November 17, 2017

**Re: Jackson Ranch Filing No. 3 (SF-17-017) - Review 1  
Project No. 61044**

M.V.E., Inc. has prepared the following response to comments contained in your June 26, 2017 comment letter concerning the above named project. Revised submittal materials are enclosed as needed. Each comment is addressed below in the order contained in your comment letter.

EXISTING
DRAINAGE MAP

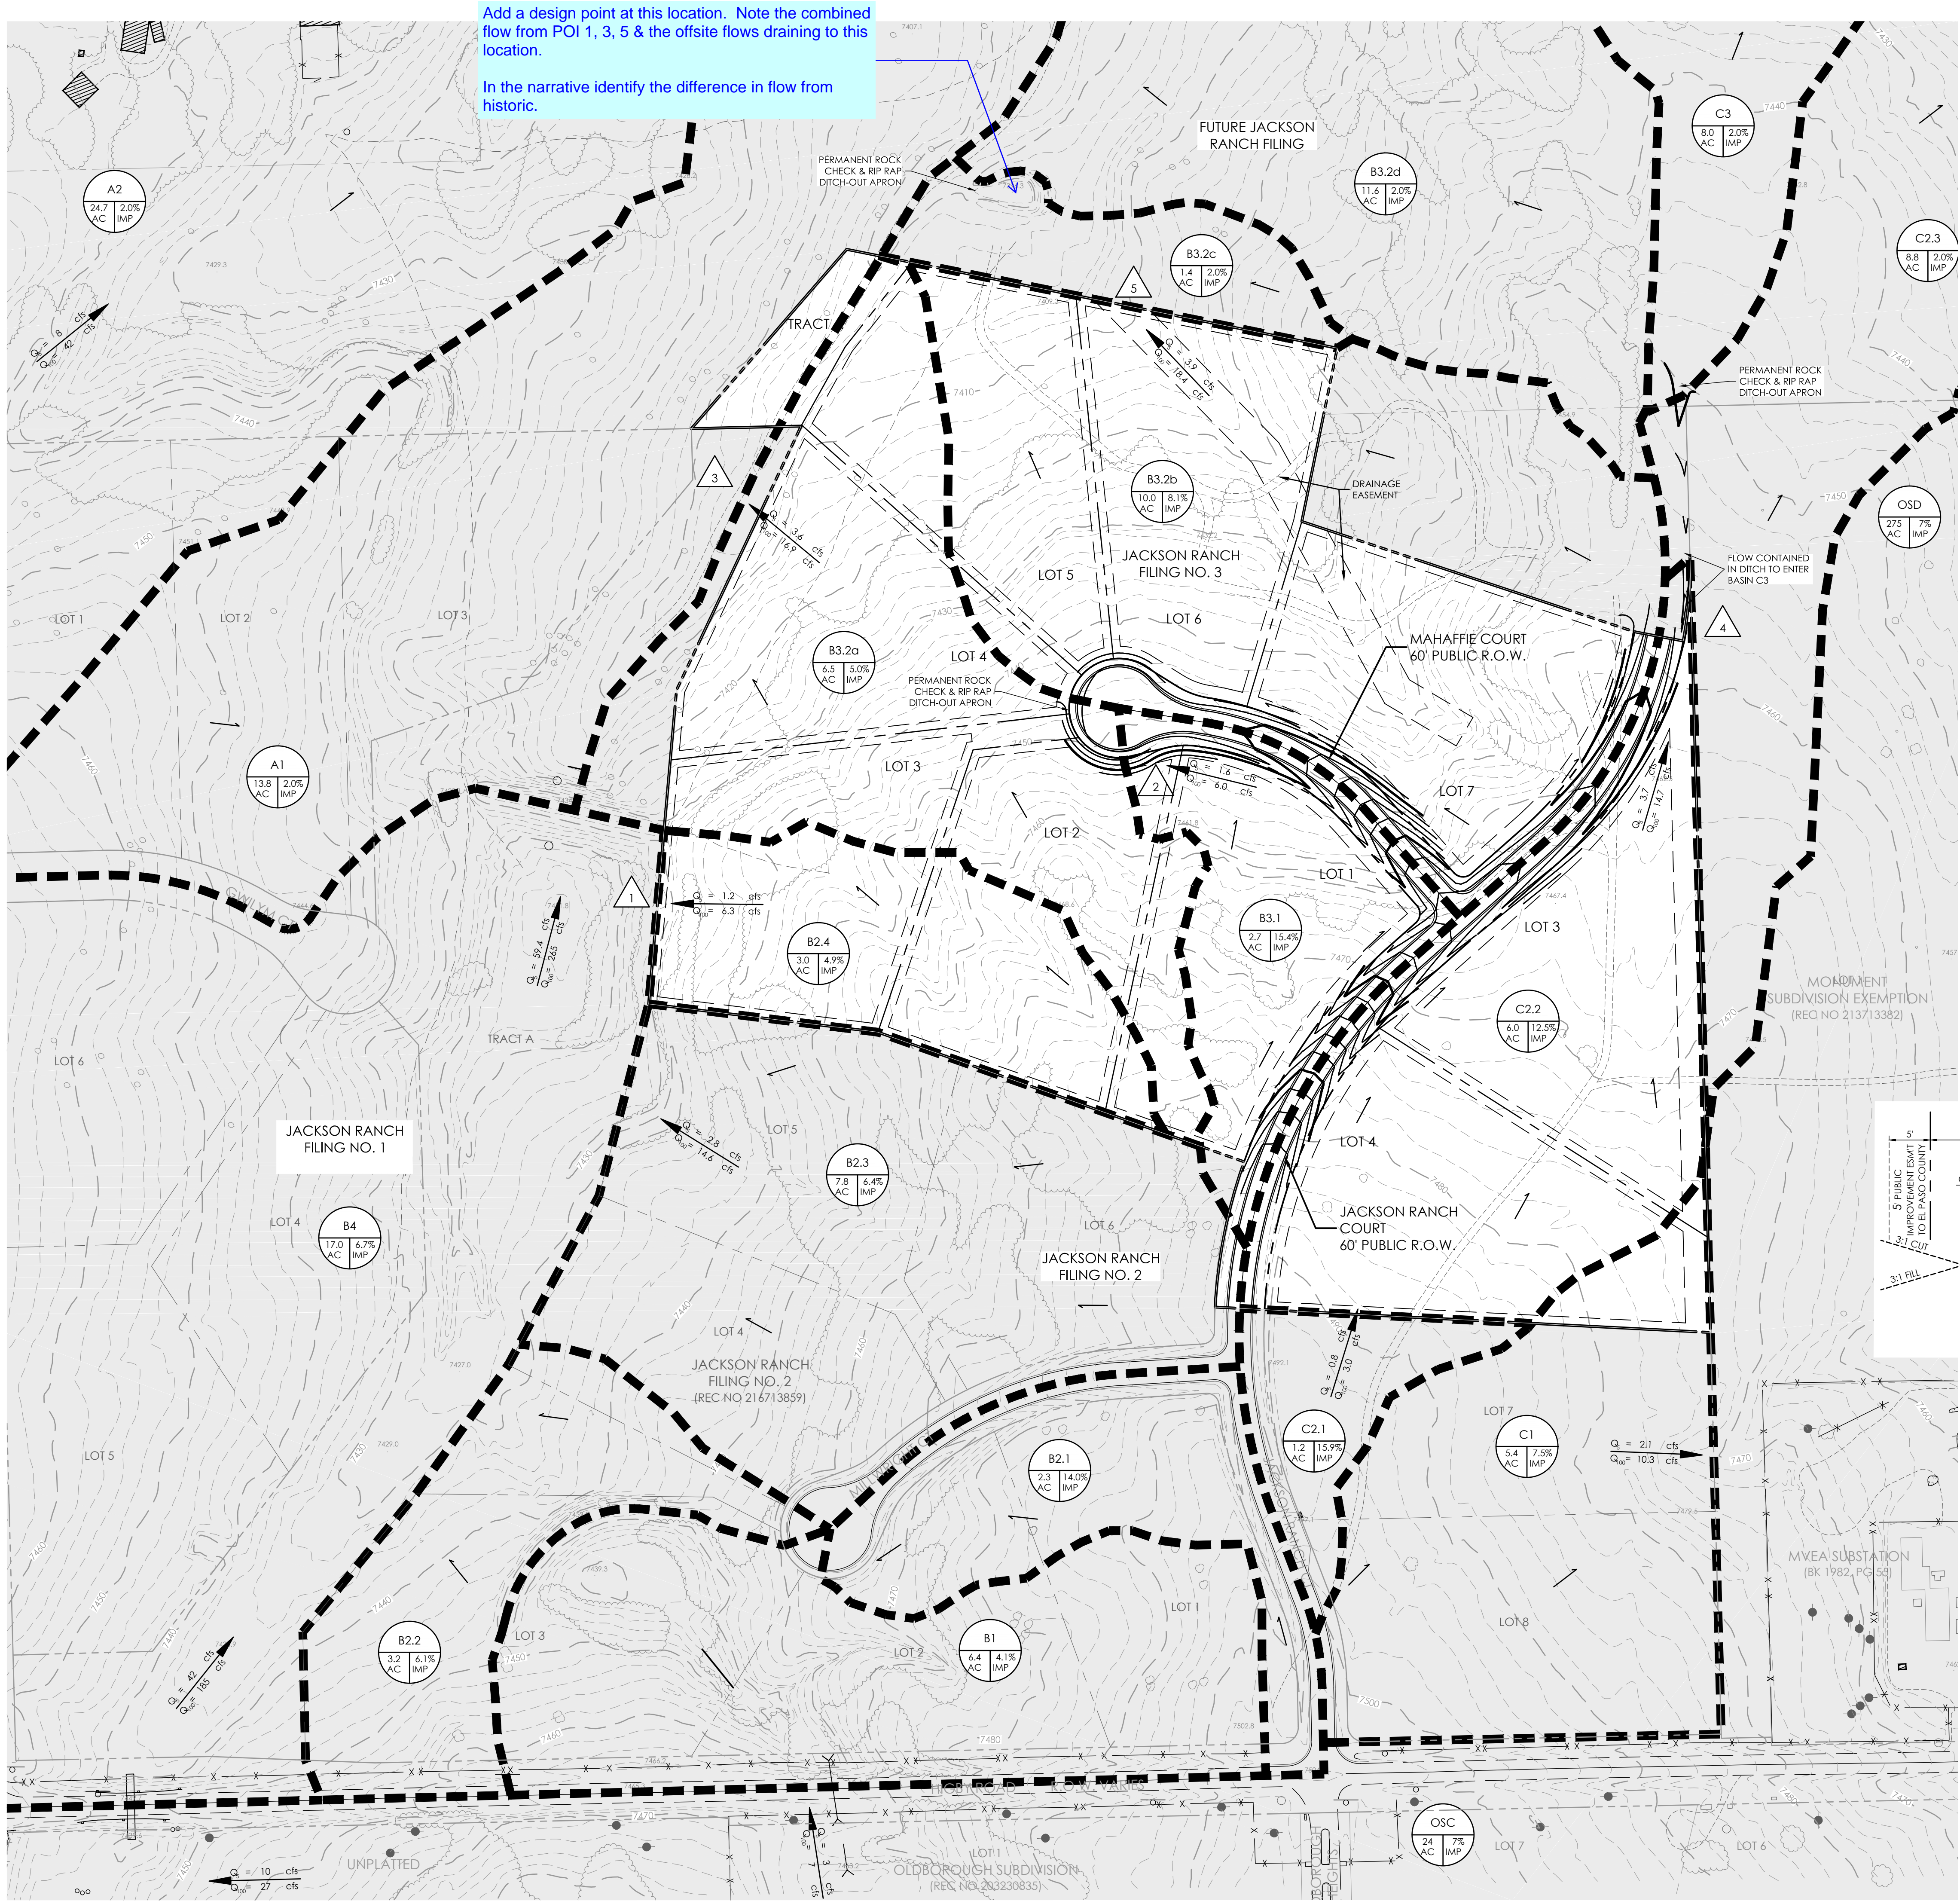
*Comment 2: Engineering redline comments on the following pdf documents will be uploaded by the project managers: Construction Drawings, Final Drainage Report, Final Plat, Financial Assurance Estimates, Grading and Erosion Control, and Traffic Impact Study. Response: Engineering redline comments have been addressed for all the referenced documents.*

**Final Drainage Report: The Final Drainage Report has been revised according to comments. Hydrologic analysis has been added to address comments regarding the developed site outflows. Ditch velocity calculations have also been added. Flows in ditches remain minimal as they are released to the existing natural drainage paths where appropriate.**
